Application No: K/51/21/PL
Site Address: 47 Golden Avenue East Preston BN16 1QX
Description of works: Erection of 1 No detached dwelling and integral garage. This site is in CIL Zone 4 and is CIL Liable as new dwelling.

Thank you for your internet representation made on 24th November 2021 which has been recorded as no objection with the comments as follows:

Drawing Title:
First Floor Plan

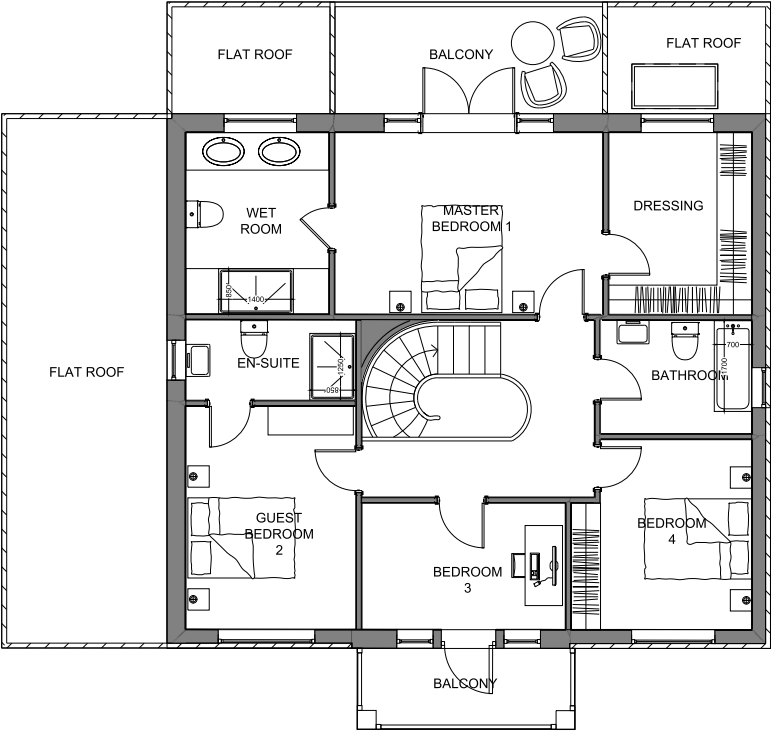
No objection providing the case officer considers whether conditions are required to prevent overlooking of neighbouring properties from the balconies.
